## Storm Water Compliance Inspection Form

**Date:** 07-30-2020

**Permit Tracking #:** NMR10025I

EROSION
CONTROL
PLAN

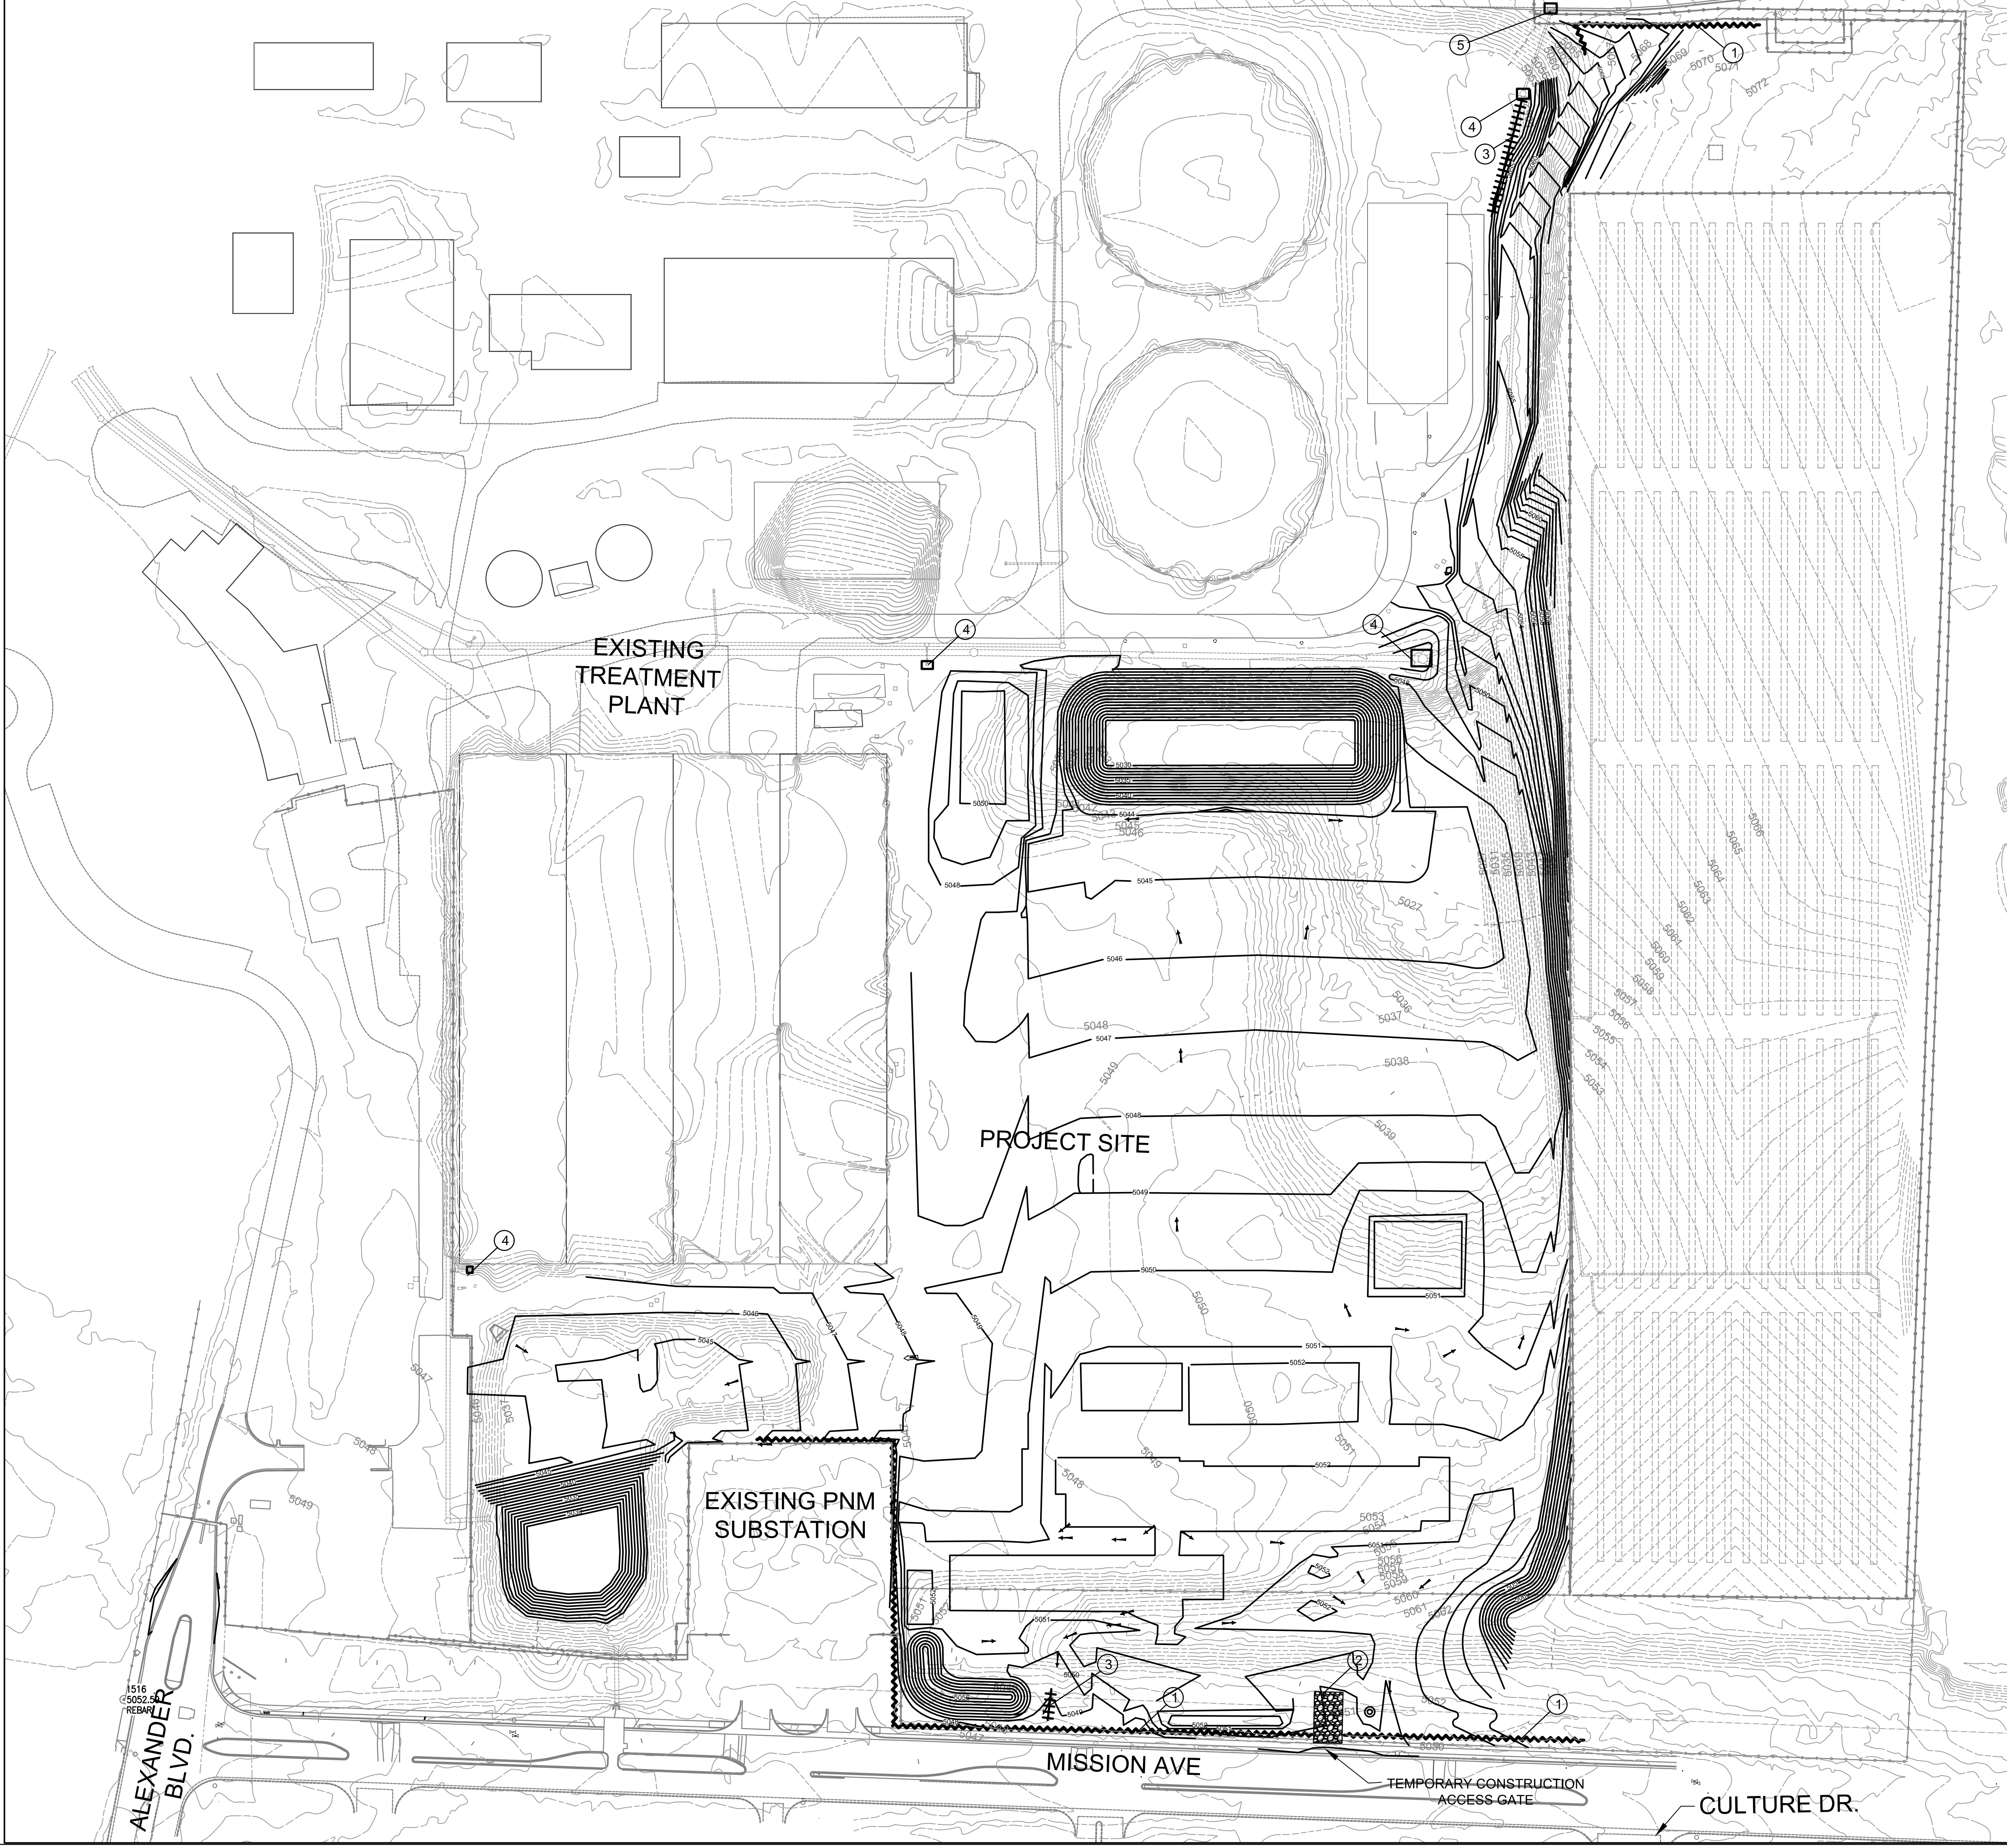
Waste Management	<input checked="" type="checkbox"/>	<input type="checkbox"/>	<input type="checkbox"/>	
Vehicle Tracking Control	<input type="checkbox"/>	<input checked="" type="checkbox"/>	<input type="checkbox"/>	Remove to complete asphalt up to the gate
Material Storage	<input checked="" type="checkbox"/>	<input type="checkbox"/>	<input type="checkbox"/>	
Dust Control	<input type="checkbox"/>	<input type="checkbox"/>	<input checked="" type="checkbox"/>	Water truck on site
Street Sweeping	<input type="checkbox"/>	<input checked="" type="checkbox"/>	<input type="checkbox"/>	Sweeping done as needed
Construction Washouts i.e. Concrete, Paint, Stucco Etc.	<input checked="" type="checkbox"/>	<input type="checkbox"/>	<input type="checkbox"/>	
Discharge Points	<input checked="" type="checkbox"/>	<input type="checkbox"/>	<input type="checkbox"/>	
Sanitary Stations	<input checked="" type="checkbox"/>	<input type="checkbox"/>	<input type="checkbox"/>

Location	Action Type	Action Required	Date Noted	Date Completed	Initials
Filter sock	Maintenance	Install filter sock at sidewalk cut outs along mission to keep sediment from street.	07-30-2020
